**Consultation Response from KC, Highways Development Management**
**2023/90668 Grange Moor Coachworks, Barnsley Road, Grange Moor, Huddersfield, WF4 4DR**
**Erection of B2/B8 Industrial Unit and associated works**
**Date Responded: 31/05/23**
**Responding Officer: A Darwin**
**Responding Ref: HDC 16-5/1**
**RECOMMENDATION: Further information required**

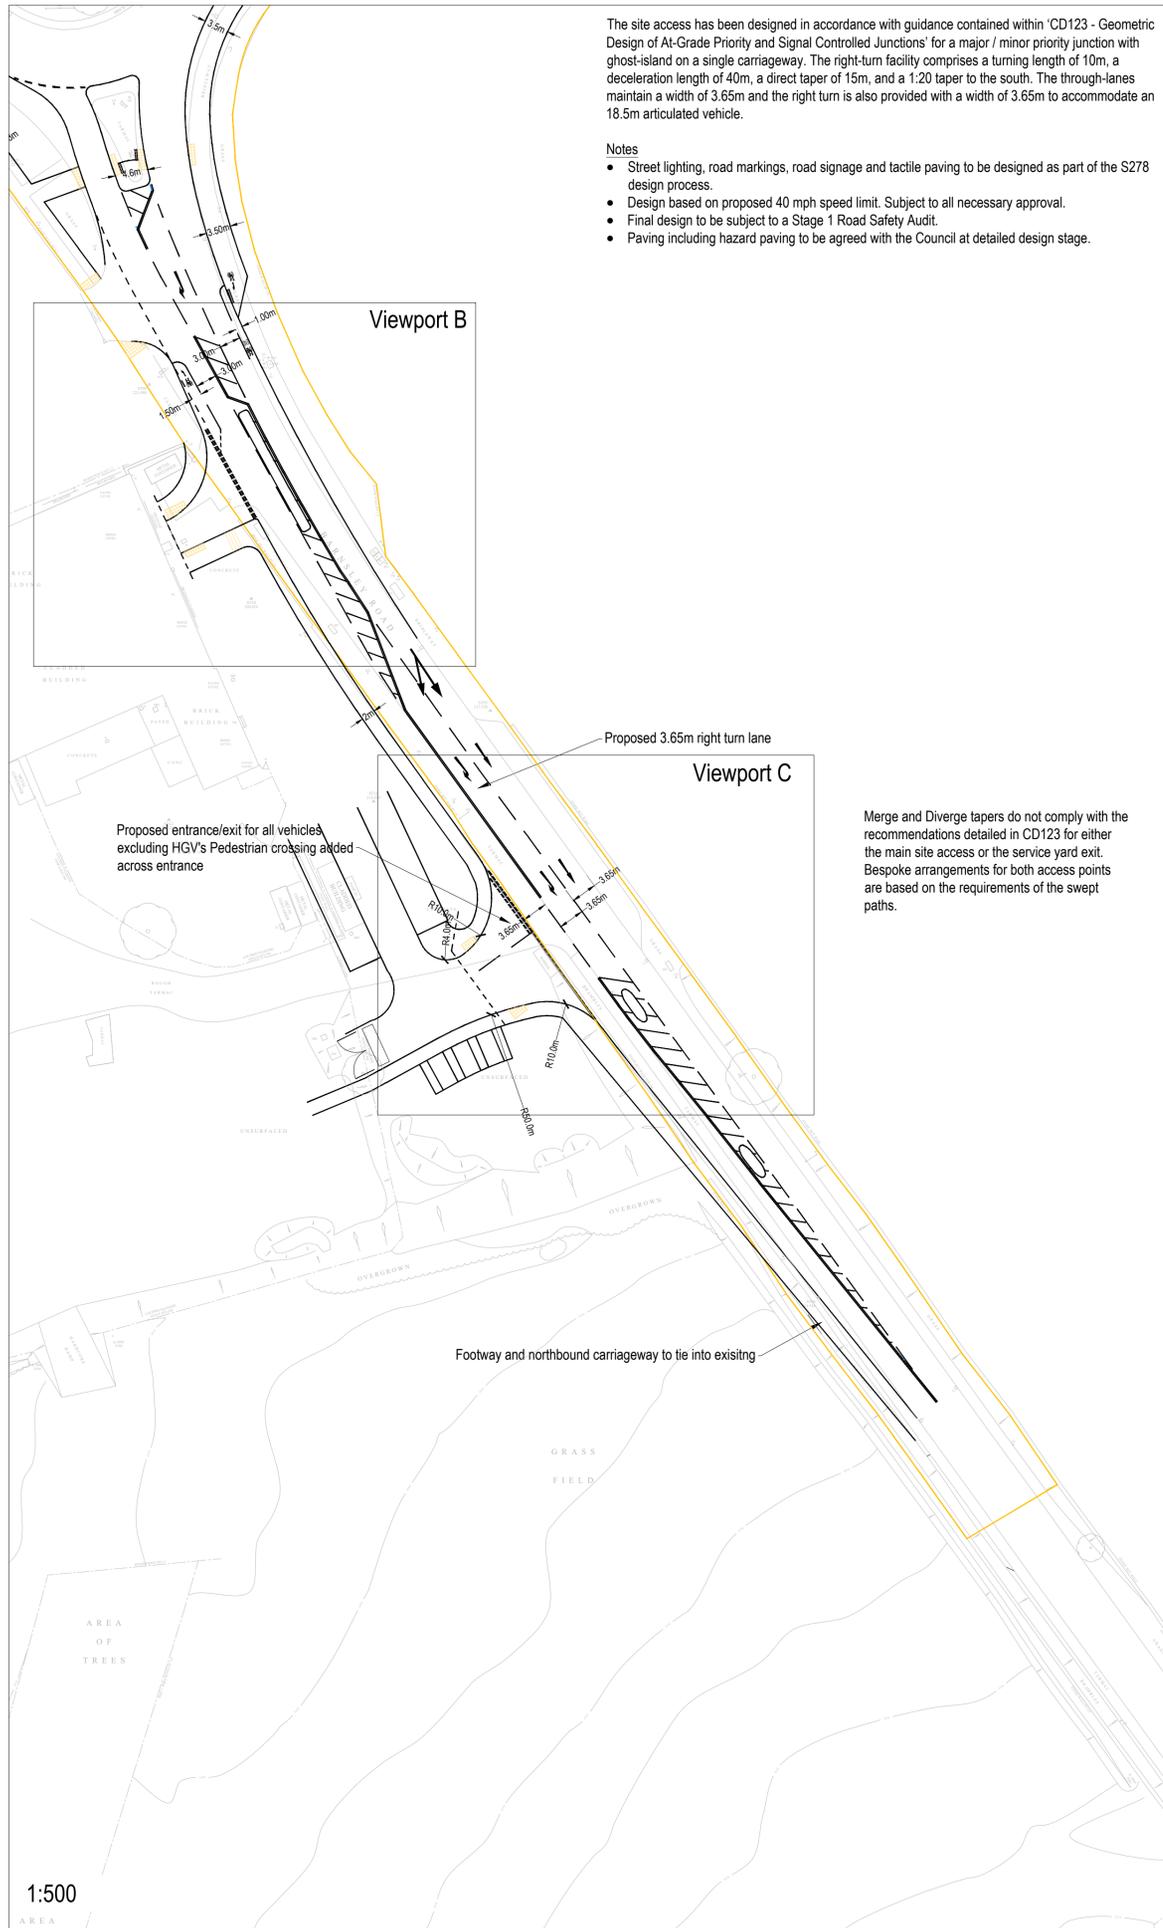
- The northern site access is proposed as an exit only from the service yard. The access is intended to be left turn only on exit, with a 8m radius on the north side and a small radius (circa 2m) on the south side to discourage right turn movements. The principle of this access point appears to be acceptable. However, the proposed layout would still allow vehicles to turn right on exit (particularly by light vehicles), which is unacceptable due to the close proximity of Grange Moor Roundabout and the lack of adequate visibility for right turning vehicles. Therefore, measures to prevent right turning vehicles must be incorporated into the proposals (e.g. a physical island on the major road, and appropriate signing/lining). The junction radii on the north side should also be amended to 10m in accordance with CD123 of DMRB.

- A 2.4x160m visibility splay has been shown to the right on exit of the site. This is in accordance with the min. standards in DMRB and is acceptable in principle. However, this will need to be rechecked once the amendments to the main site access have been incorporated (see further comments below).

- It is unclear whether a footway is proposed on the south side of the access, which is shown on the development site layout but not on the highway works plan. This should be incorporated into the proposals, and should demonstrate a suitable pedestrian crossing point that is inset into the junction in accordance with good practice.

- No swept path analysis (SPA) has been provided for turning HGV's at the junction. This should be provided for all HGV types, including max. legal rigid and articulated vehicles (including 18.5m long artics) and high reach fire appliance (should these be required). Further amendments to the access arrangements may then be required, including the provision of tapers, to ensure that HGV's can turn without encroaching the central hatching.

- The main site access is proposed as a two-way access for light vehicles and entry only for HGV's. The principle of this access point appears to be acceptable. However, there appears to be a number of design elements that do not accord with DMRB standards that need to be addressed in a revised design, with full details of compliance or any proposed departures from standard clearly identified.

- The proposed junction alignment is not perpendicular to Barnsley Road, as required by DMRB (see para. 5.4 of CD123). Given that there are no constraints that would preclude this, this must be addressed in the revised proposals.

- There appears to be a small (circa 6m) radius on the north side of the junction, and a larger (circa 10m) radius on the south side. This is not in accordance with DMRB and Kirklees Councils standards that require min. 10m radius in this situation.

- No swept path analysis (SPA) has been provided for turning HGV's at the junction. This should be provided for all HGV types, including max. legal rigid and articulated vehicles (including 18.5m long

artics) and high reach fire appliance (should these be required). Further amendments to the access may then be required, including the provision of entry tapers, to ensure that inbound HGV's can turn without encroachment of the right turn lane on Barnsley Road or the outbound traffic lane from the site.

- 2.4x160m and 2.4x130m visibility splays have been shown at the access, looking to the southeast and northwest respectively. Whilst it is acknowledged that the 130m splay is measured up to the exit of Grange Moor Roundabout where speeds are likely to be lower, this is a departure from standard that needs to be identified on the plans and Stage 1 RSA Brief to allow the RSA Team to fully consider this matter. Similarly, the 'x' distance of 2.4m is not in accordance with DMRB (min. 4.5m is required, see p3.8/3.82 of CD123) and may need to be increased (subject to the final junction modelling assessments once these have been agreed) or alternatively a departure from standard would need to be identified.

- Junction visibility to the right of the main site access would be blocked by vehicles waiting to exit the public EV charging bay access to the southeast. This is not acceptable, and the EV charging bay access should be removed from the proposals. Any other obstructions to visibility (e.g. signage, street furniture of vegetation etc) should be clearly identified on the proposal plans, and relocated where necessary.

- Out of hour security gates are proposed at the site access. However, these need to be inset further into the site access, to ensure that a 18.5m articulated vehicle could stand clear of Barnsley Road.

- The proposed right turn lane is 3.0m wide, which is below the minimum width of 3.5m identified in DMRB (p6.10 of CD123). The TA suggest that the remaining design elements for the right turn lane are in accordance with DMRB. However, this needs to be clearly demonstrated on plan. It is noted that additional queuing length may be required in the right turn lane, which needs to be established once the junction modelling has been agreed (see further Transport Assessment comments below).

- No footways are proposed around the bellmouth of the site access junction, and no pedestrian crossing facilities have been shown. These facilities should be incorporated into the proposals, and should demonstrate a suitable pedestrian crossing point that is inset into the junction in accordance with good practice. A pedestrian refuge island may also be necessary at the junction to reduce the pedestrian crossing distance, which will be dependant on the final junction arrangement.

- There is a traffic island proposed on the southeast side of the right turn lane. This does not currently serve any purpose and should be removed from the proposals (unless it is to be used as a pedestrian island – see further comments below regarding bus stop provision).

- There is currently a layby for southeast bound traffic located immediately adjacent to the proposed right turn lane, and the interaction of these features could create safety problems. Therefore, the plans should clearly indicate whether this layby is to remain or not, and if retained, whether any amendments are required, so this matter can be considered as part of the Stage 1 Road Safety Audit.

- A separate access is proposed to the southeast of the main site access to serve the 4 no. public EV charging bays. There are a number of concerns with this access arrangement as identified below, which cannot be readily addressed. Therefore, this access is not acceptable and should be removed from the proposals. However, there may still be scope to accommodate the public EV charging bays, should they be served from the main site access instead.
- The proposed right turn lane is only 2.5m wide, which is below DMRB standards. Whilst the other geometric parameters relating to the right turn lane have not been confirmed, it is also clear that the right turn lane length is substantially below standard.
- Due to the limited junction spacing between this access and the main site access, vehicles waiting to exit the EV charging access would block visibility from the main site access.

Existing Highway Boundary

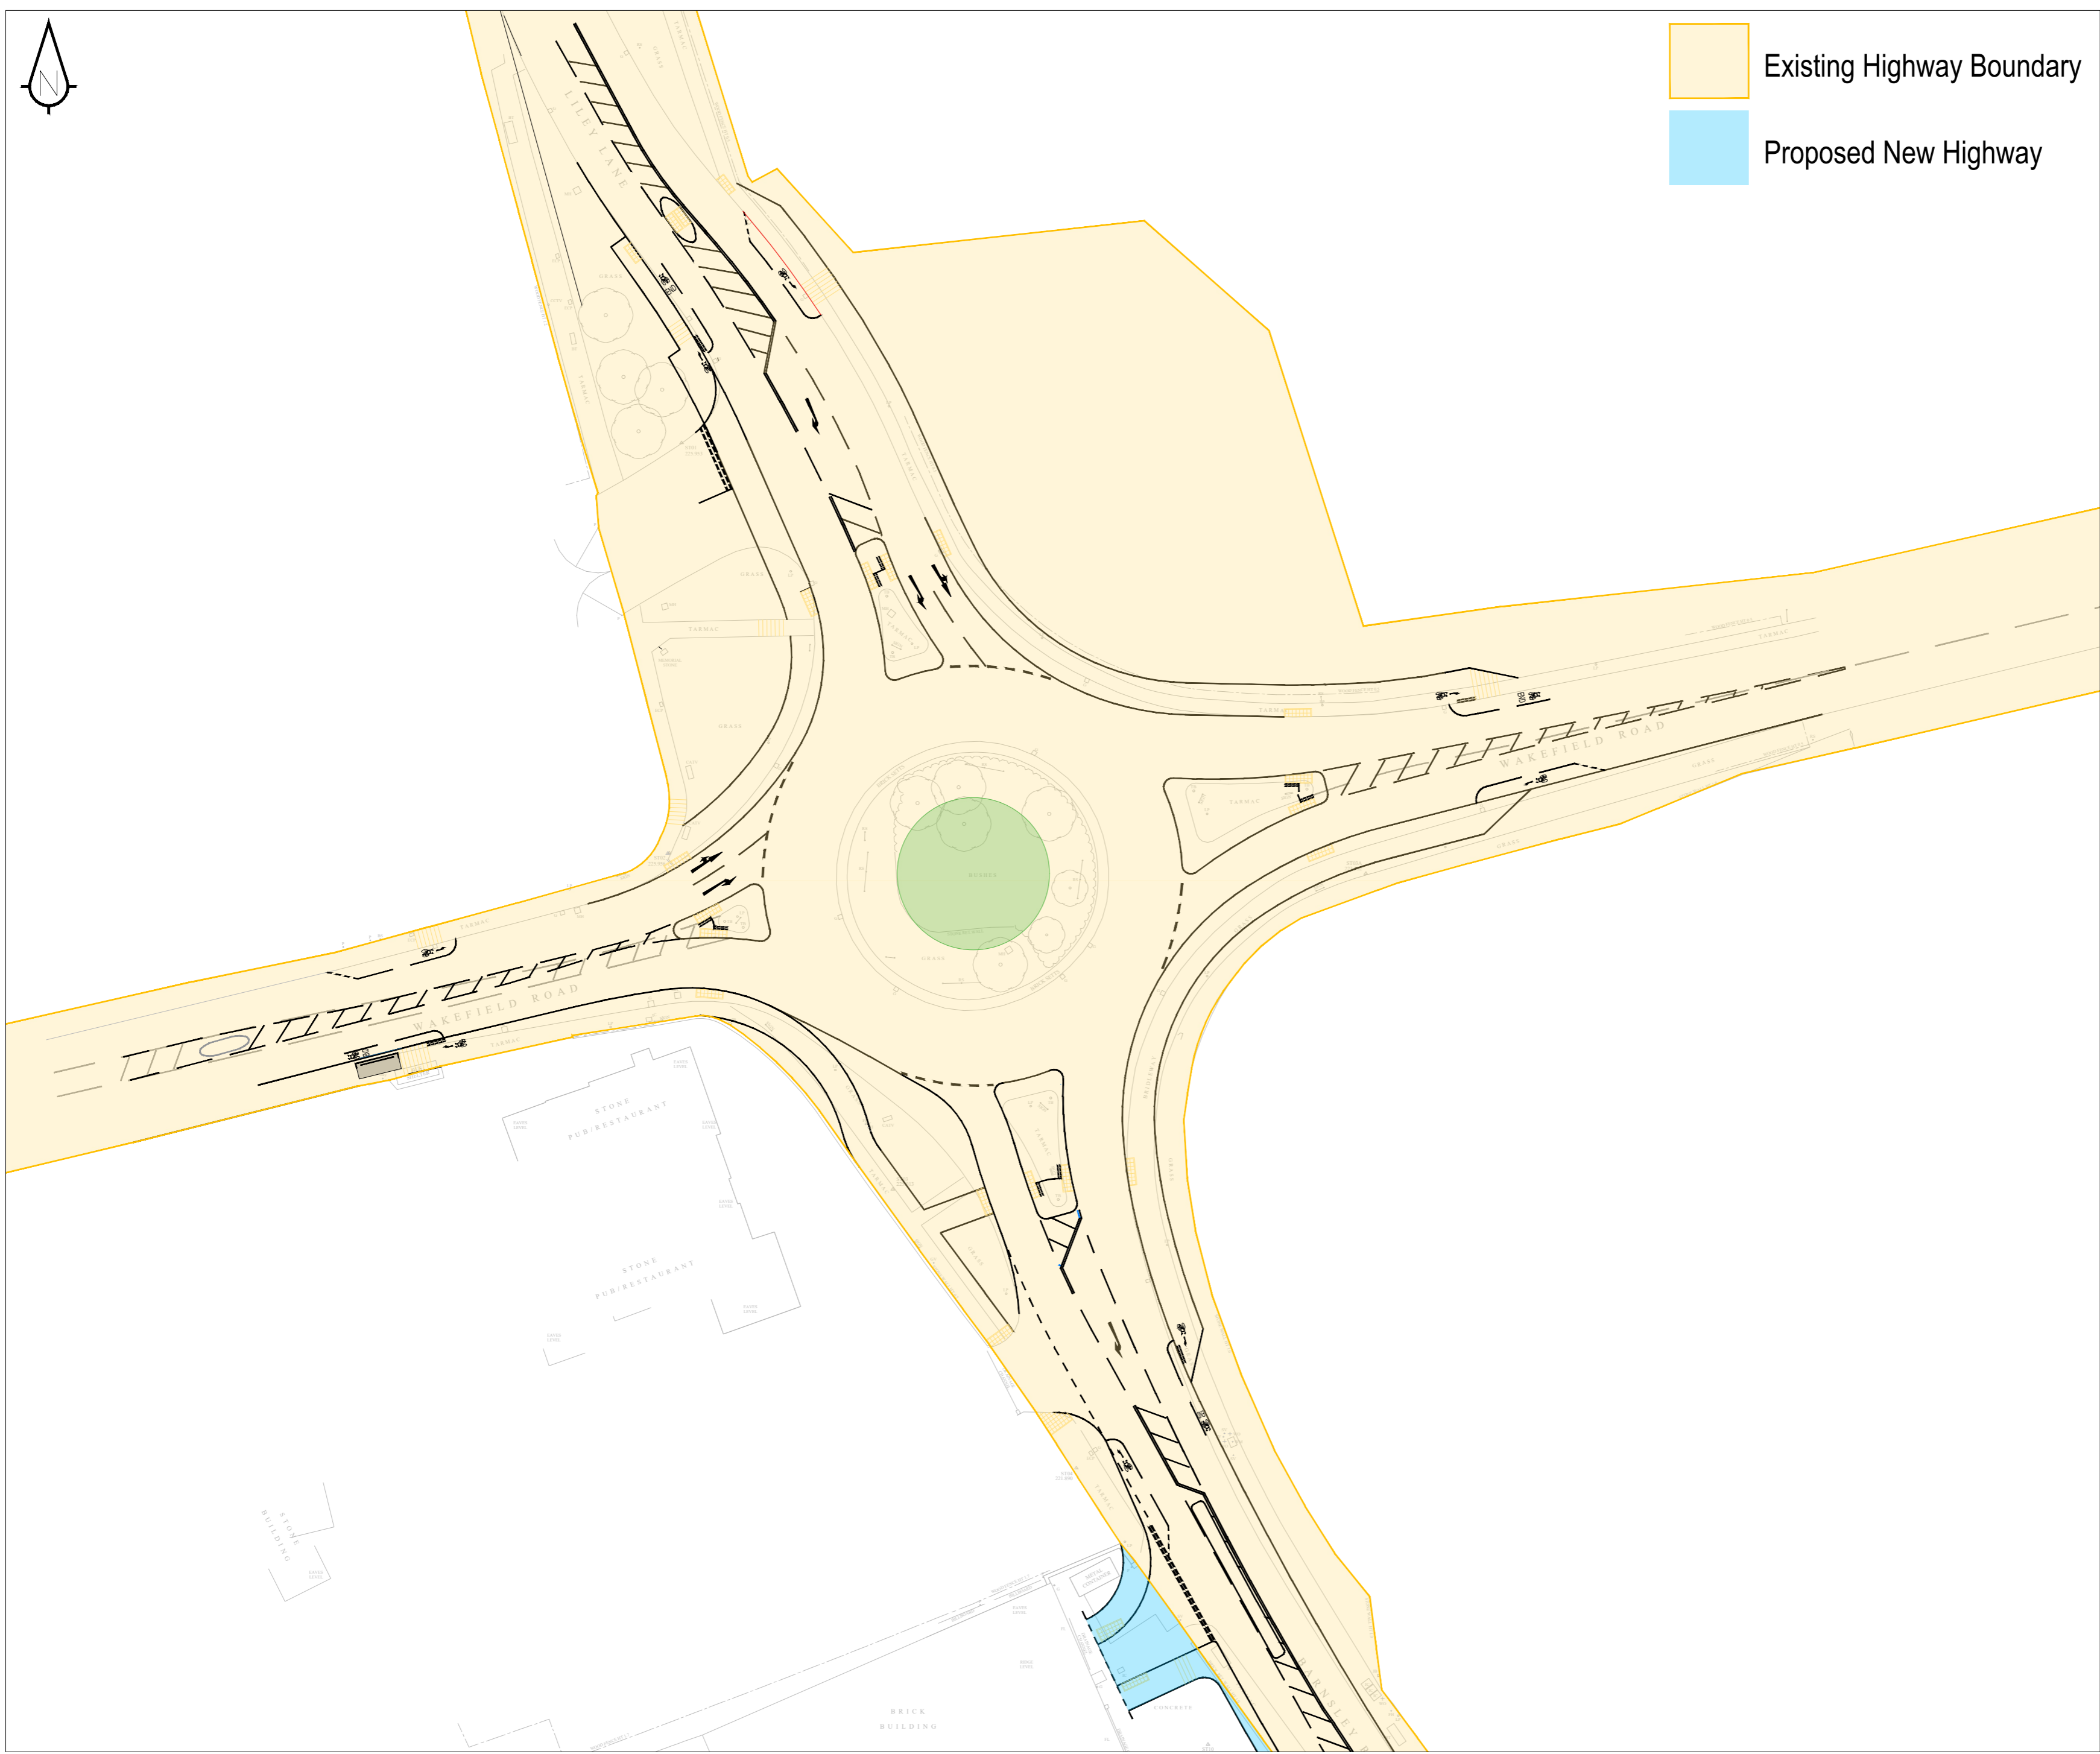
- The extent of the existing and proposed highway should be clearly marked on the submission drawings, which should include the junction bell-mouths and all necessary visibility splays/sight-lines.
